## EL PASO COUNTY STORMWATER MANAGEMENT PLAN CHECKLIST

GRADING AND EROSION CONTROL PLAN

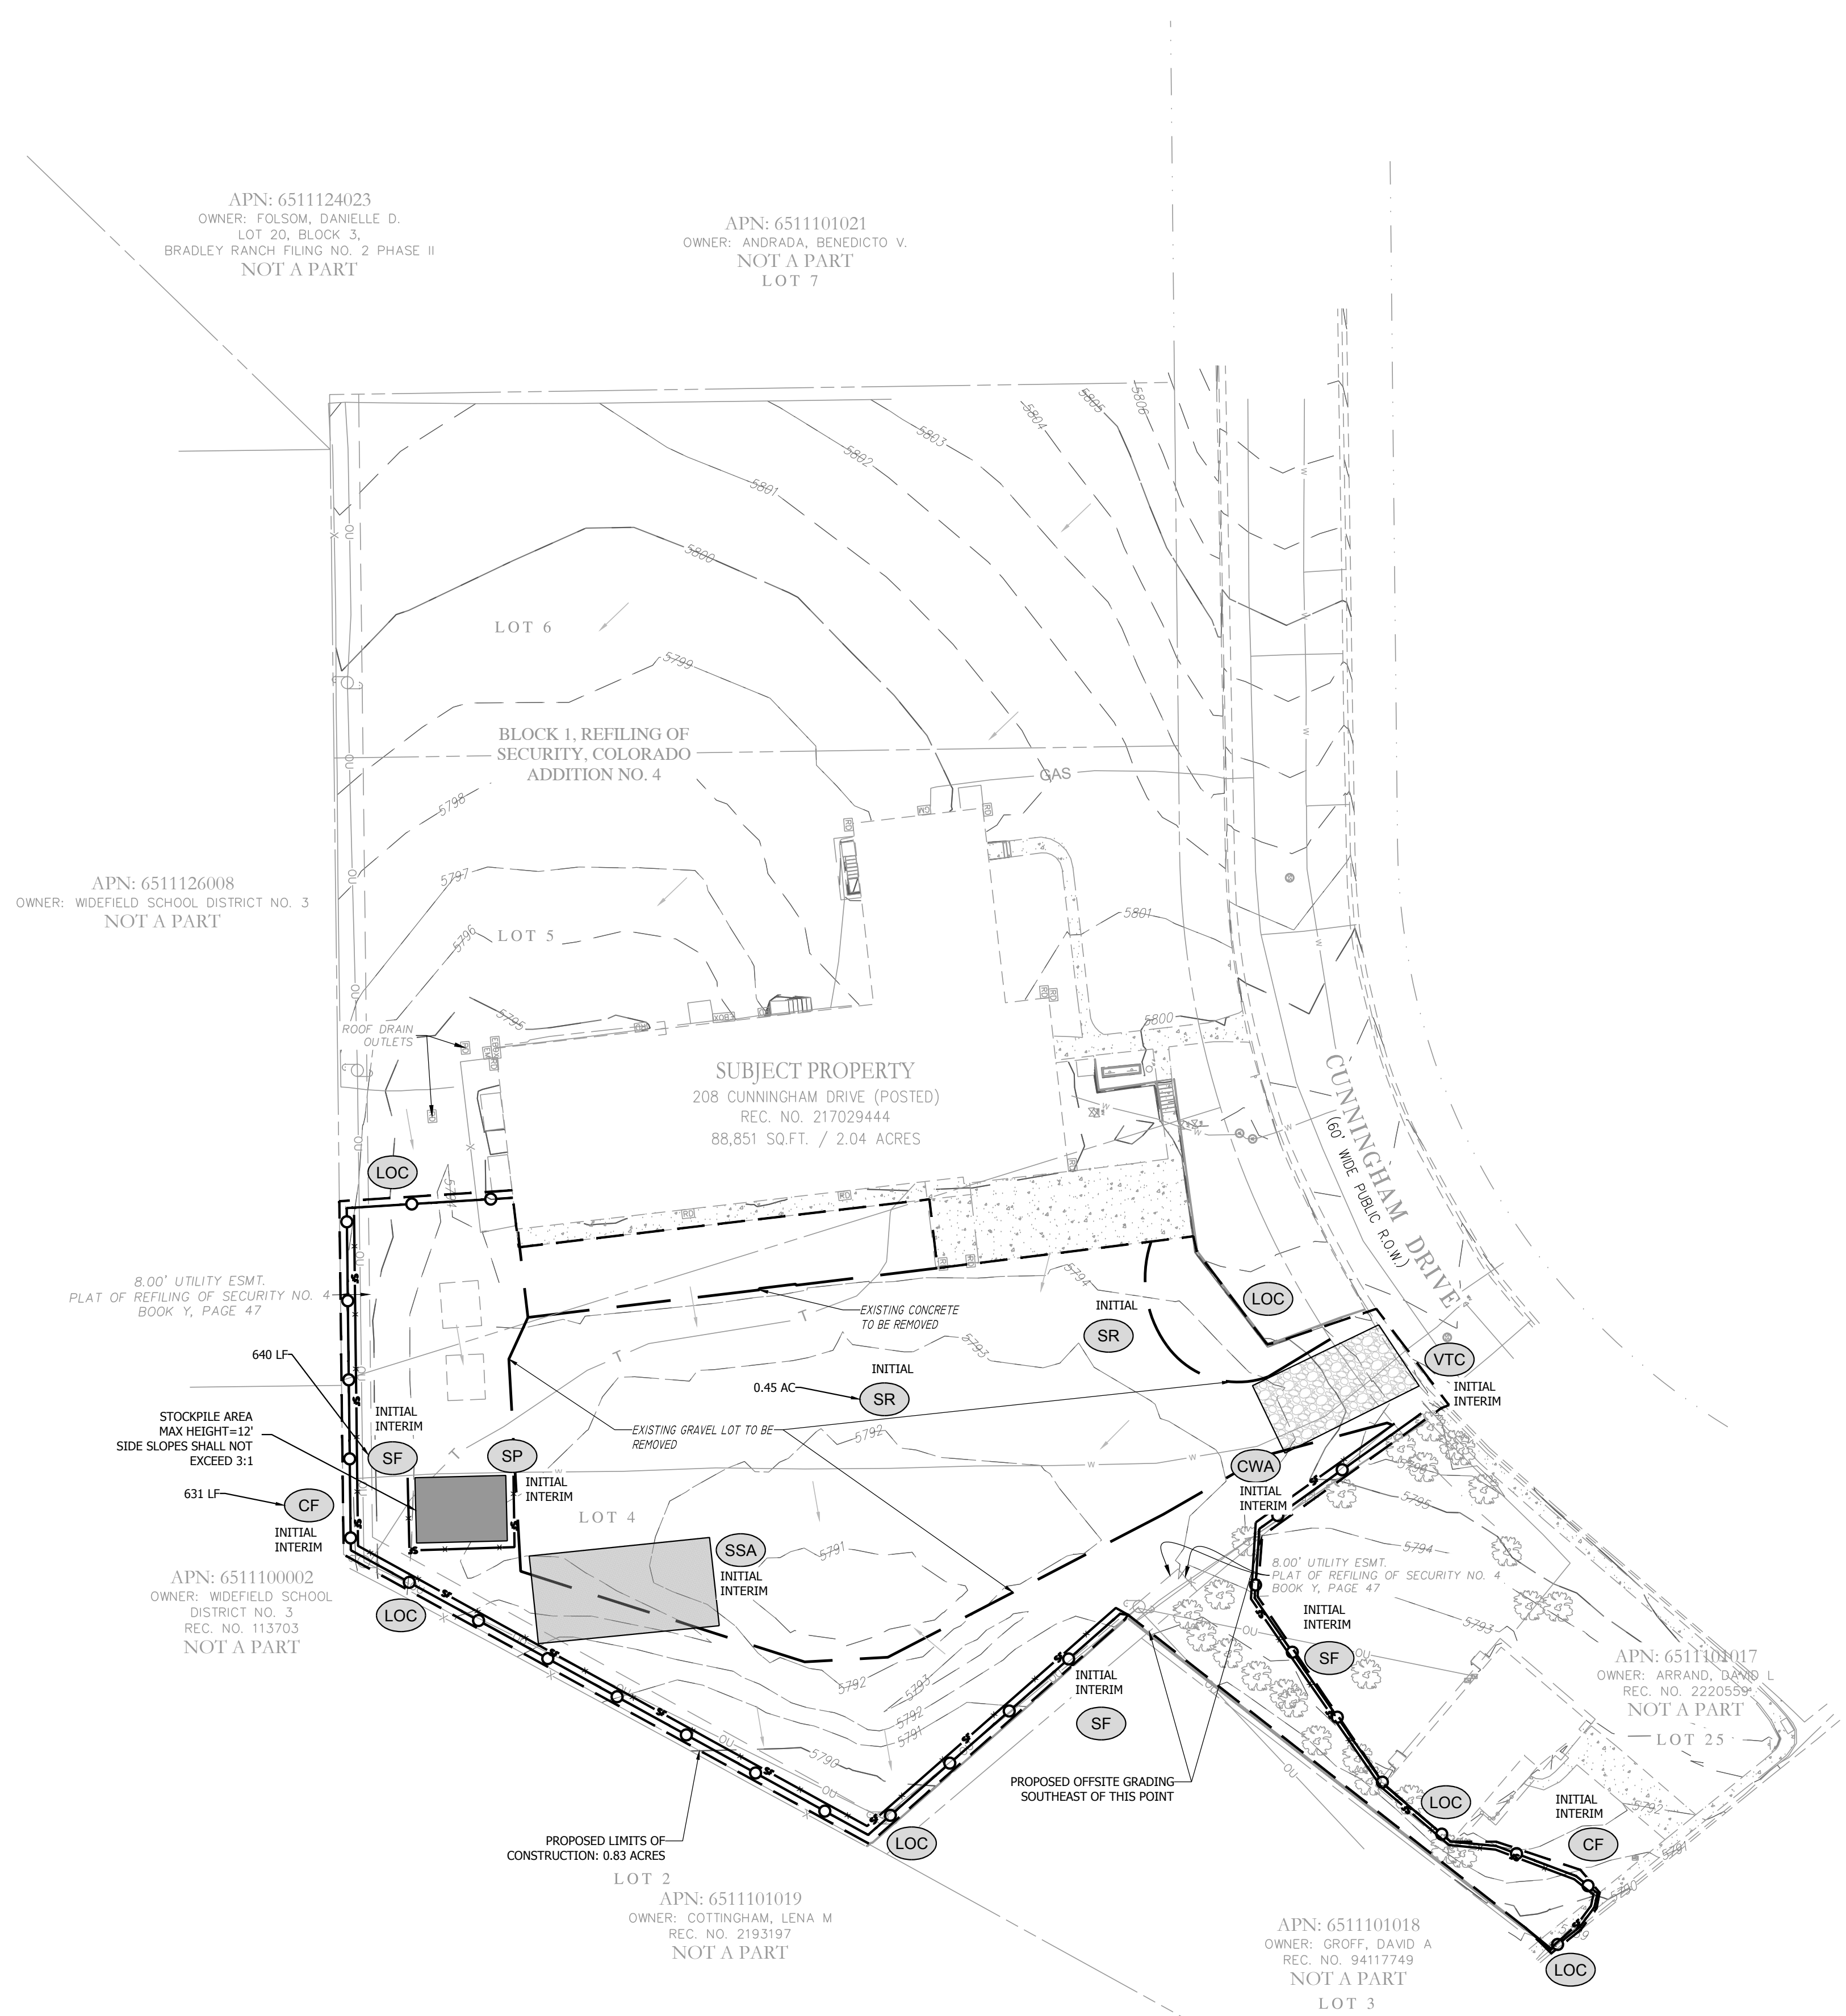
Applicant	EPC
17	SWMP Map to include:		
17a	construction site boundaries		Y
17b	flow arrows to depict stormwater flow directions <b>FLOW ARROWS ADDED</b>		N
17c	all areas of disturbance		Y
17d	areas of cut and fill <b>CUT/FILL ADDED TO THE PLANS</b>		N
17e	areas used for storage of building materials, soils (stockpiles) or wastes		Y
17f	location of any dedicated asphalt / concrete batch plants		N/A
17g	location of all structural control measures		Y
17h	location of all non-structural control measures		Y
17i	springs, streams, wetlands and other surface waters, including areas that require maintenance of pre-existing vegetation within 50 feet of a receiving water		Y
18	Narrative description of all structural control measures to be used. Modifications to EPC standard control measures must meet or exceed County-approved details		Y
19	Description of all non-structural control measures to be used including seeding, mulching, protection of existing vegetation, site watering, sod placement, etc.		Y

SM-3 Construction Fence (CF)

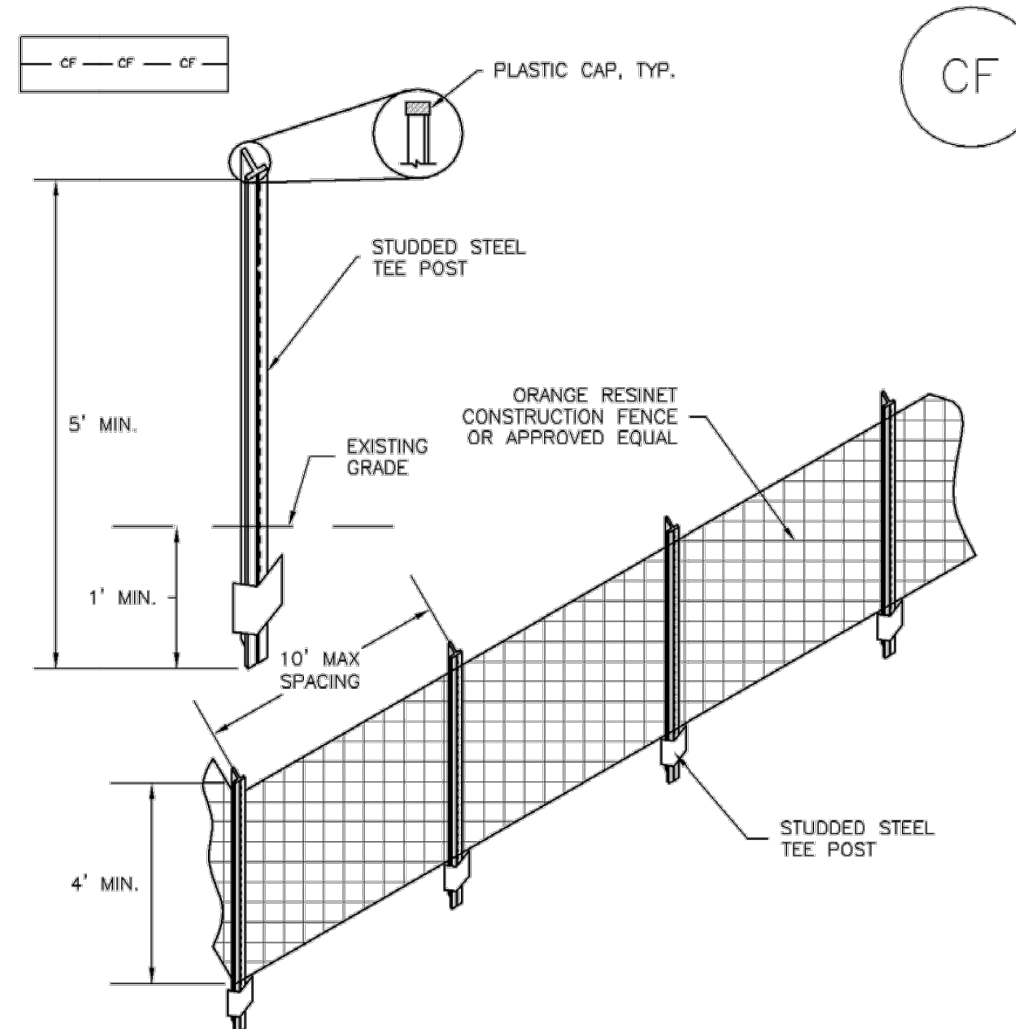
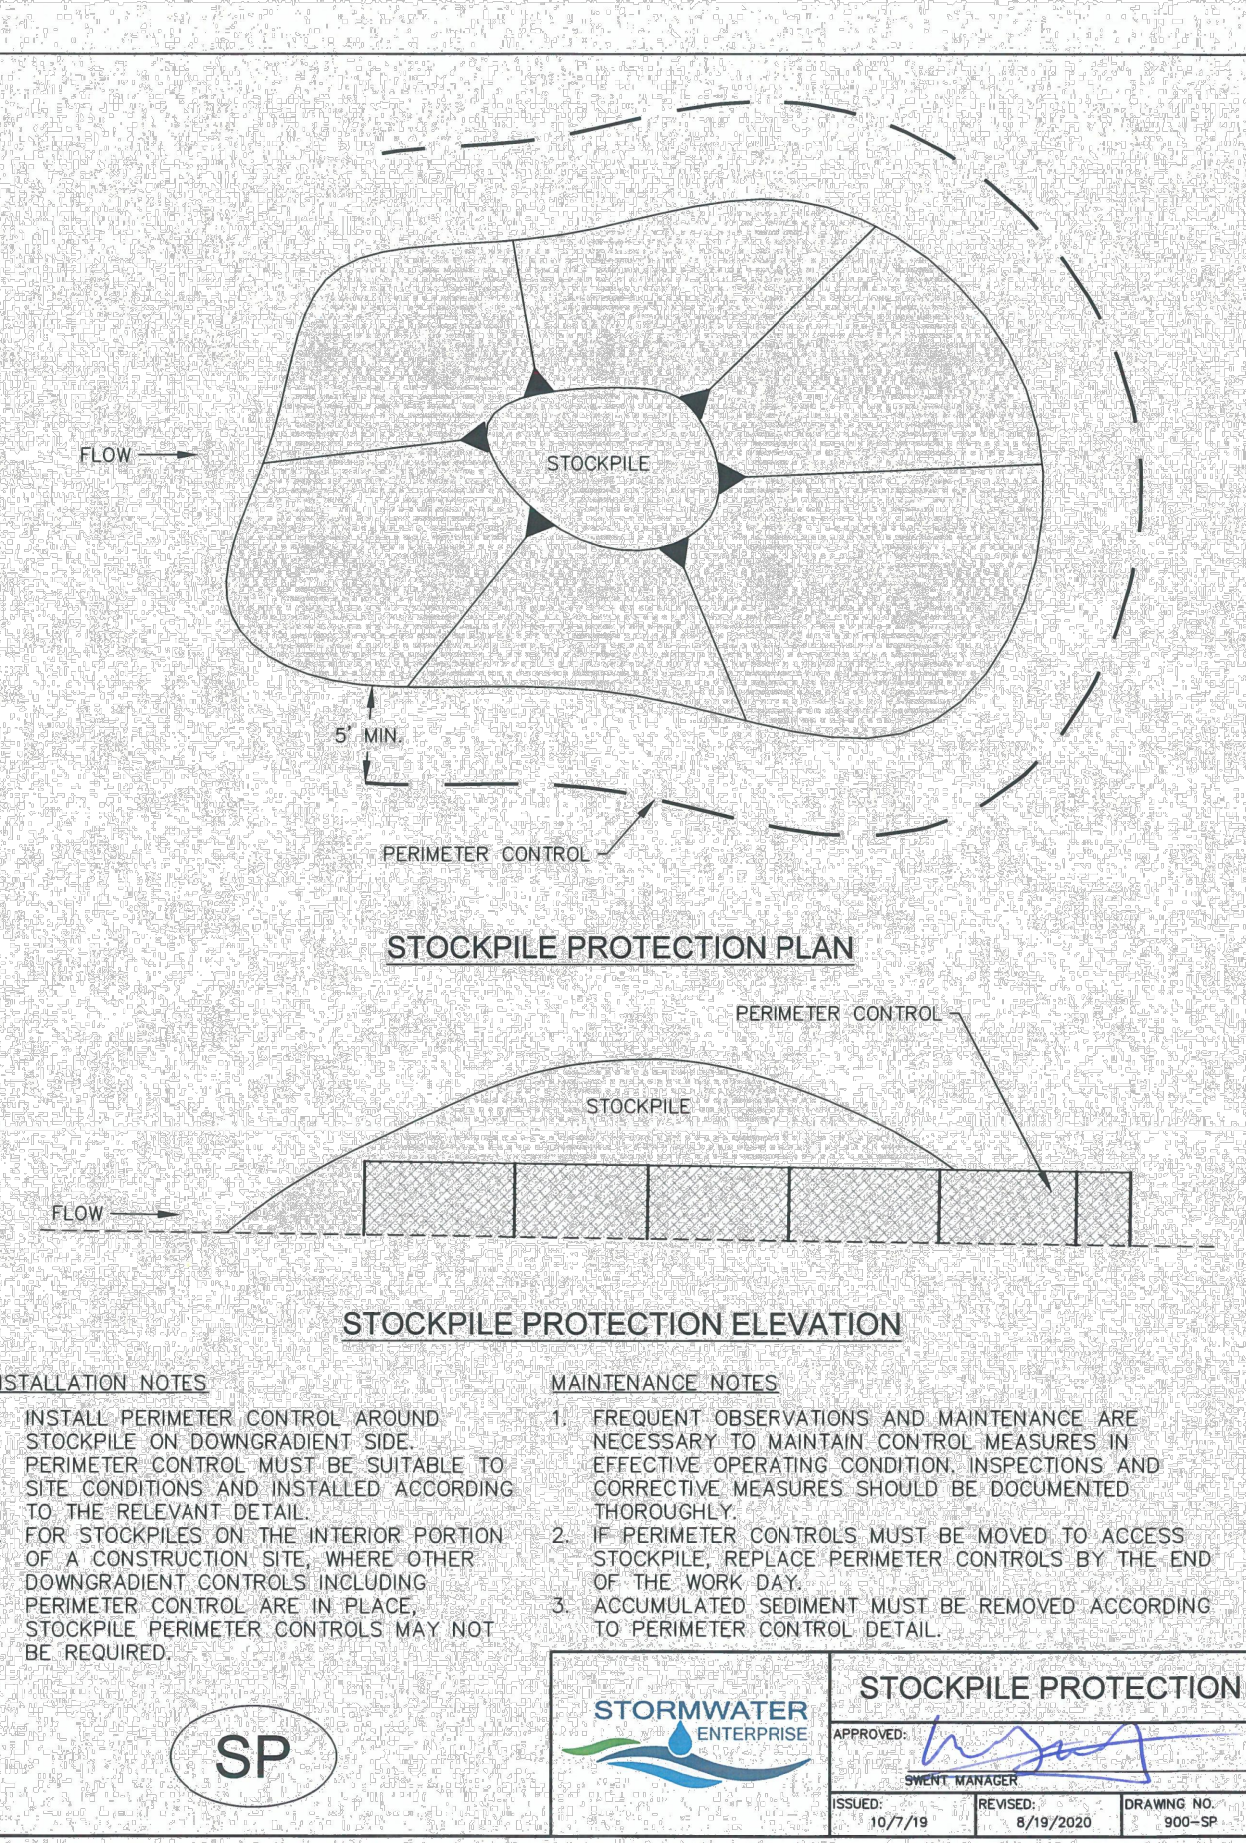
20	Technical drawing details for all control measure installation and maintenance; custom or other jurisdiction's details used must meet or exceed EPC standards <b>DETAILS ADDED</b>		N
21	Procedure describing how the SWMP is to be revised		Y
22	Description of Final Stabilization and Long-term Stormwater Quality (describe nonstructural and structural measures to control SW pollutants after construction operations have been completed, including detention, water quality control measure etc.)		Y
23	Specification that final vegetative cover density is to be 70% of pre-disturbed levels		Y
24	Outline of permit holder inspection procedures to install, maintain, and effectively operate control measures to manage erosion and sediment		Y
25	Record keeping procedures identified to include signature on inspection logs and location of SWMP records on-site		Y
26	If this project relies on control measures owned or operated by another entity, a documented agreement must be included in the SWMP that identifies location, installation and design specifications, and maintenance requirements and responsibility of the control measure(s)		Y
